WEST SUSSEX COUNTY COUNCIL CONSULTATION

TO:	Arun District Council FAO: Mr S Davis
FROM:	WSCC - Highways Authority
DATE:	11 May 2020
LOCATION:	Springfields Hook Lane Chichester PO20 3TE
SUBJECT:	AL/27/20/PL Demolition of the existing dwelling & construction of 2 No. 2-bed, 3 No. 3-bed & 4 No. 4 bed houses including access, landscaping & associated works (resubmission following AL/51/19/PL).
DATE OF SITE VISIT:	n/a
RECOMMENDATION:	No Objection
S106 CONTRIBUTION TOTAL:	n/a

Proposed Block Plan 1:500@A3

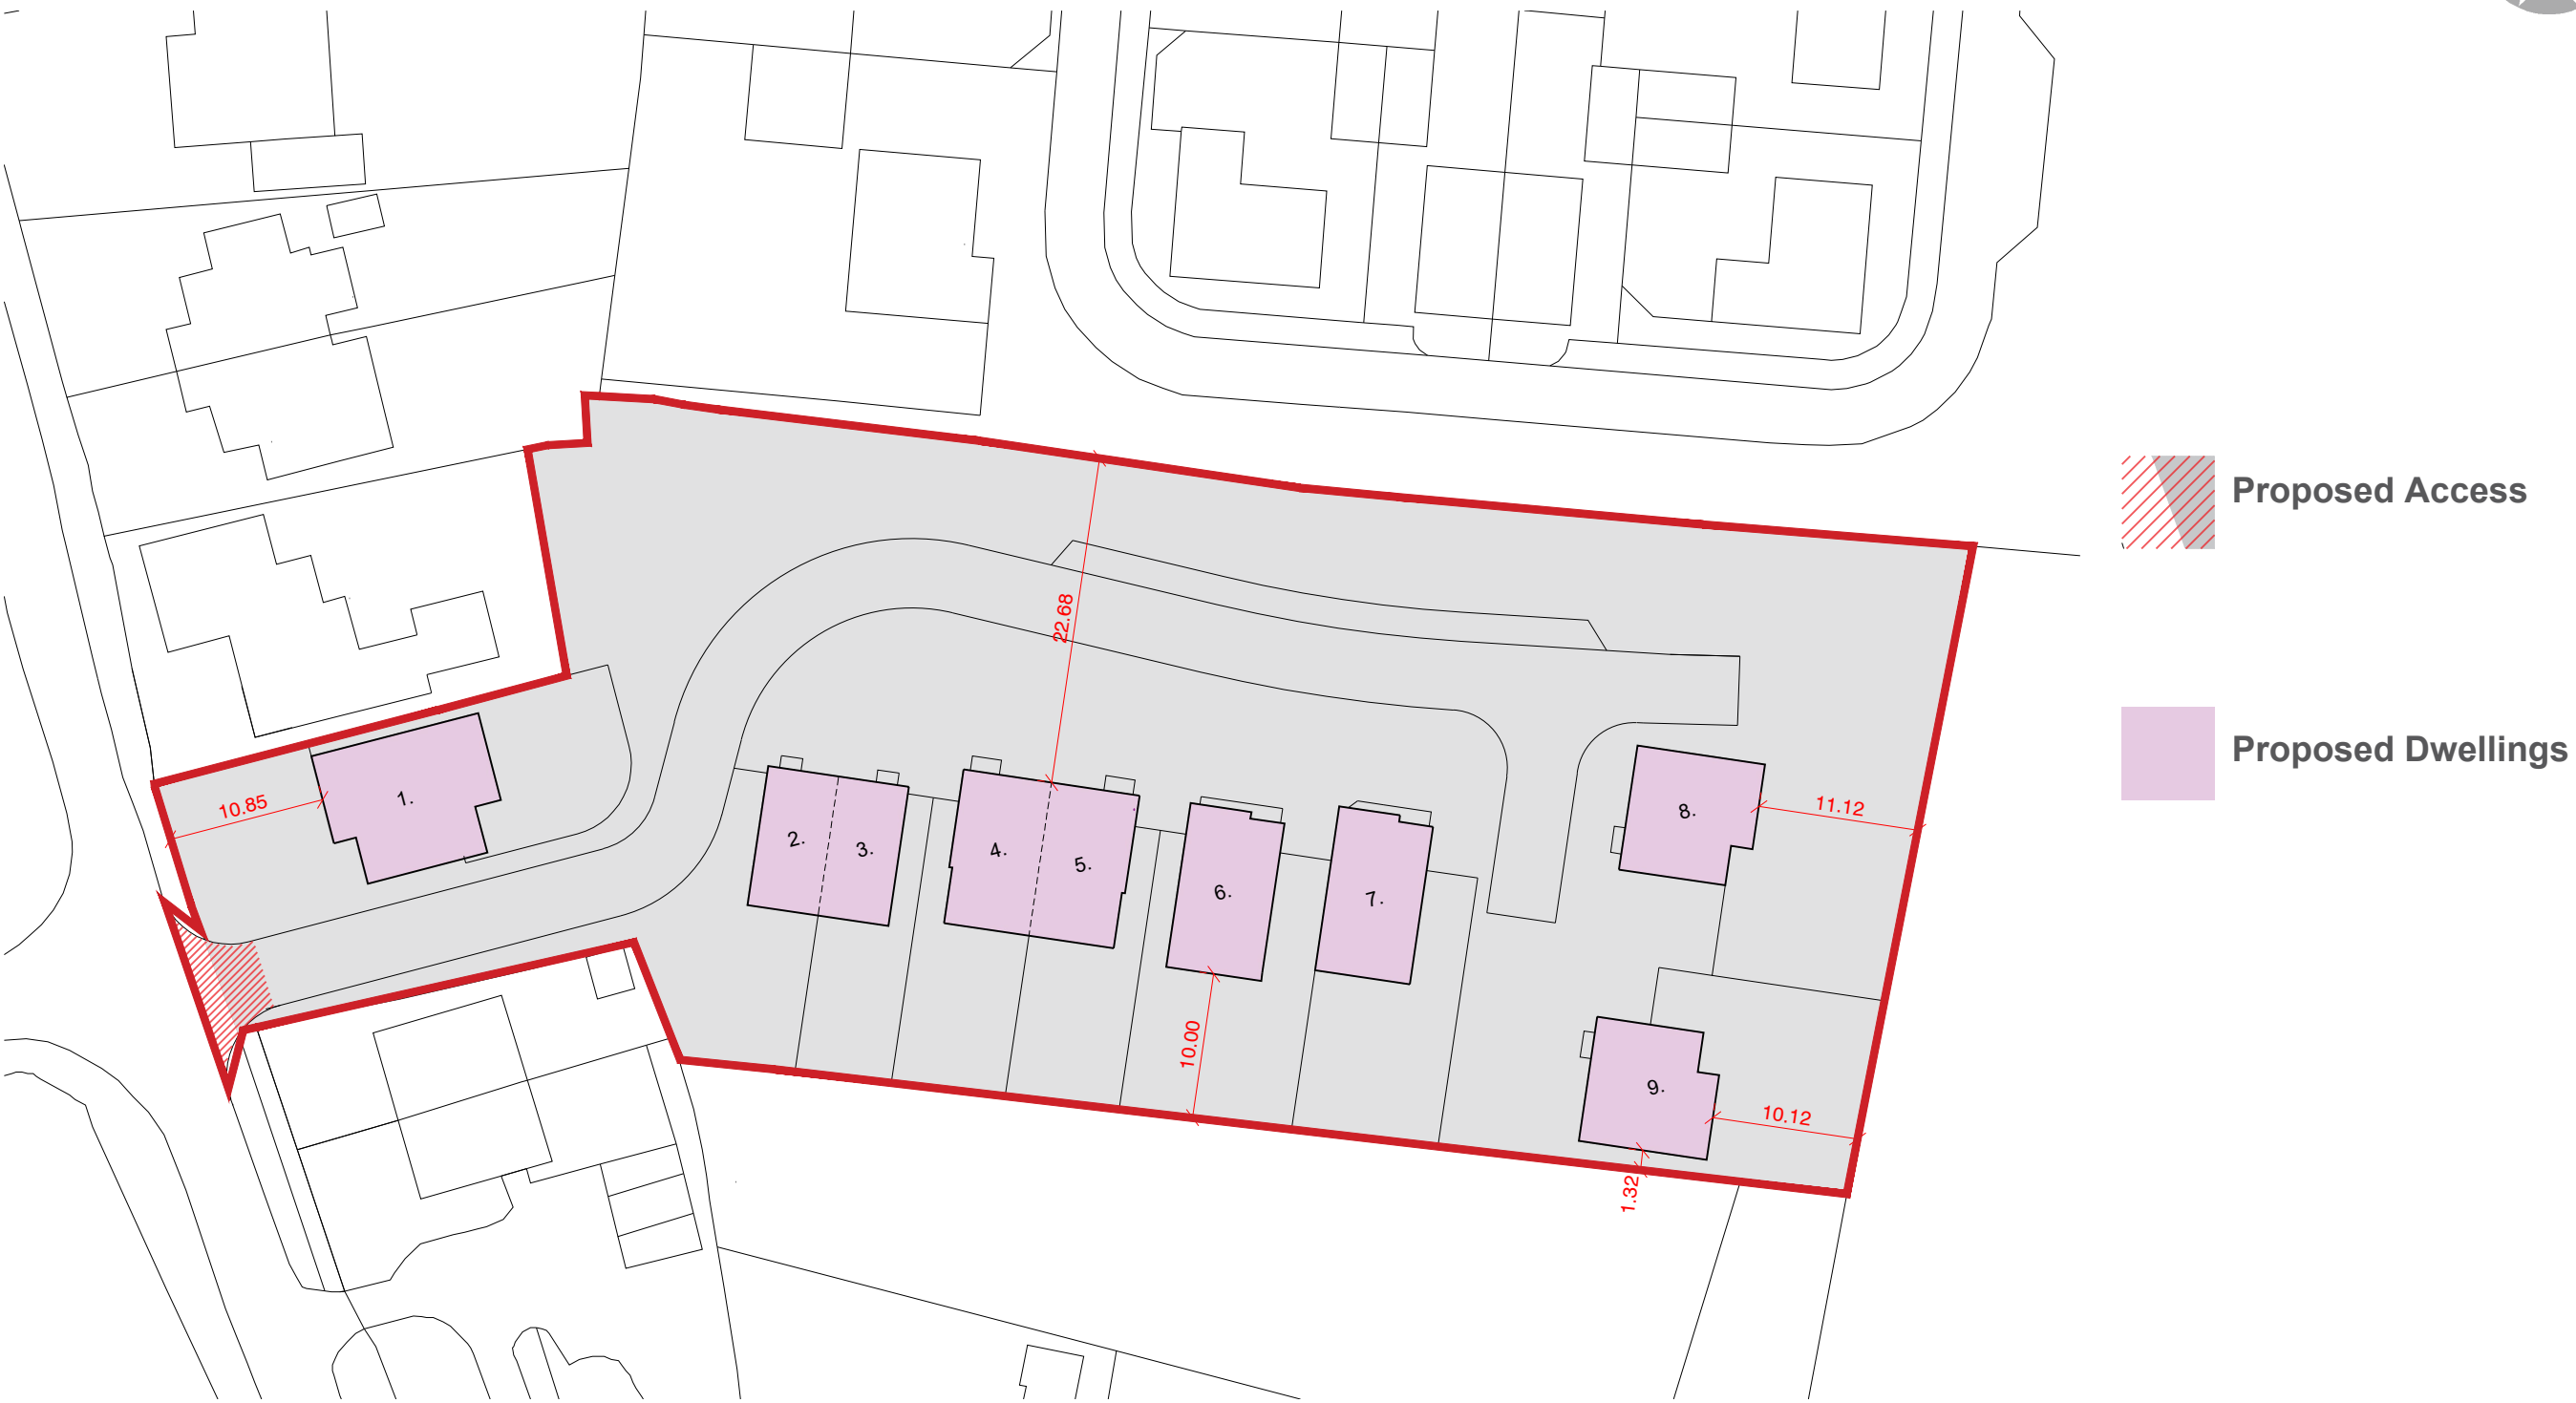
The LHA have reviewed the submitted documents; although there has been no transport note submitted as there previously was. When reviewing drawing SK04 Rev 5 it's clear that the proposed access remains in the same location, with some internal site layout changes. There are no changes on the plan that would raise concern with the LHA. The application is now for 9 dwellings and 28 parking spaces, which meets with the WSCC Parking Demand Calculator, although the Application Form and drawing state 29.

No part of the development shall be first occupied until visibility splays of 43 metres by 43 metres from a 2.4m set back have been provided at the proposed site vehicular access onto Hook Lane in accordance with plans and details to be submitted to and approved in writing by the Local Planning Authority. Once provided the splays shall thereafter be maintained and kept free of all obstructions over a height of 0.6 metre above adjoining carriageway level or as otherwise agreed.

No part of the development shall be first occupied until the vehicle parking and turning spaces have been constructed in accordance with the approved plan. These spaces shall thereafter be retained for their designated use.
